From: Peter Champion [REDACTED]
Sent: 19 January 2018 14:45
To: Simon Davis
Subject: RE: BR/314/17/NMA

From: Simon Davis [REDACTED]
Sent: 19 January 2018 14:25
To: 'Peter Champion' <[REDACTED]>
Subject: RE: BR/314/17/NMA

Title
PROPOSED ELEVATIONS

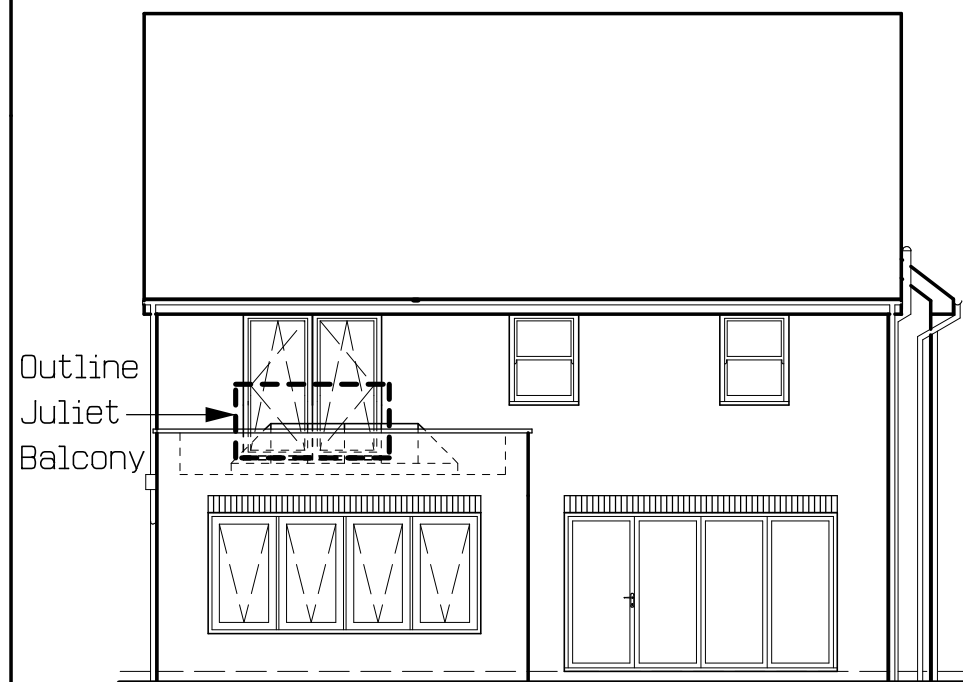
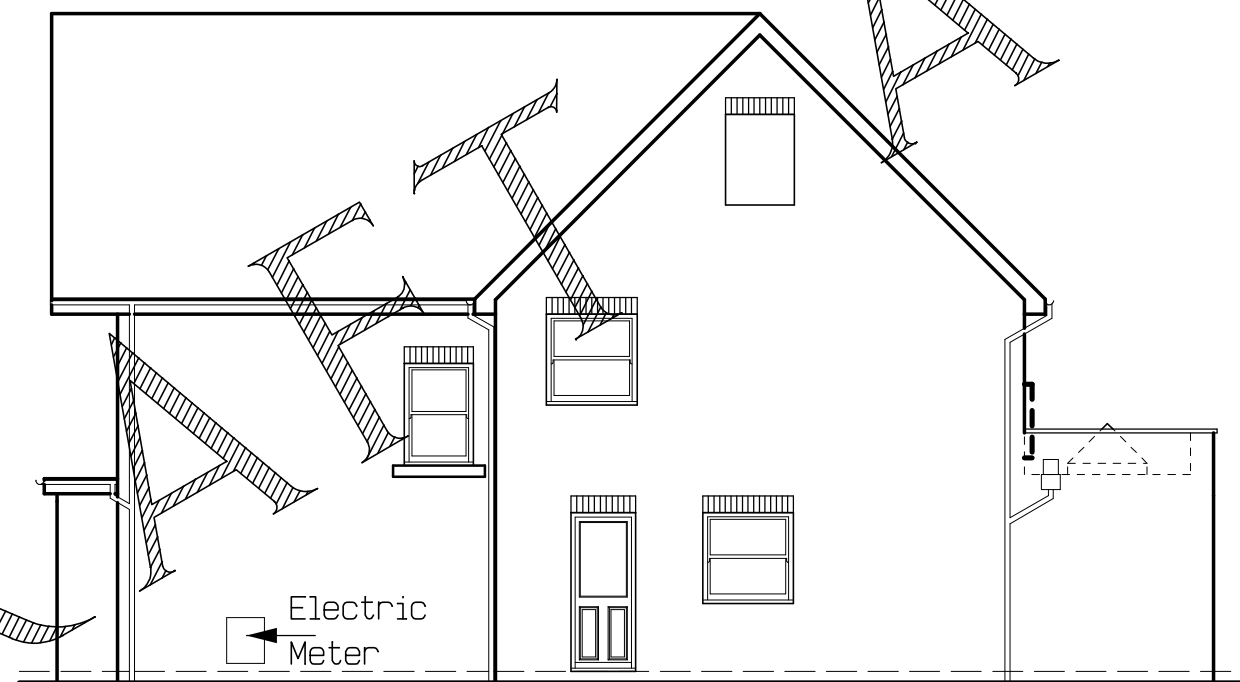
I have just been looking at your application. You are applying for a new gable elevation but you have not submitted a new elevation plan to me. I cannot therefore make a decision on this until I have this.

I am currently unsure whether the change in roof design would be considered to materially alter the external appearance of the building. I am checking this with my team leader.

Please find attached the revised elevation plans, which I trust will assure you that the gable is to be identical in appearance to the adjoining plots 2 & 3.
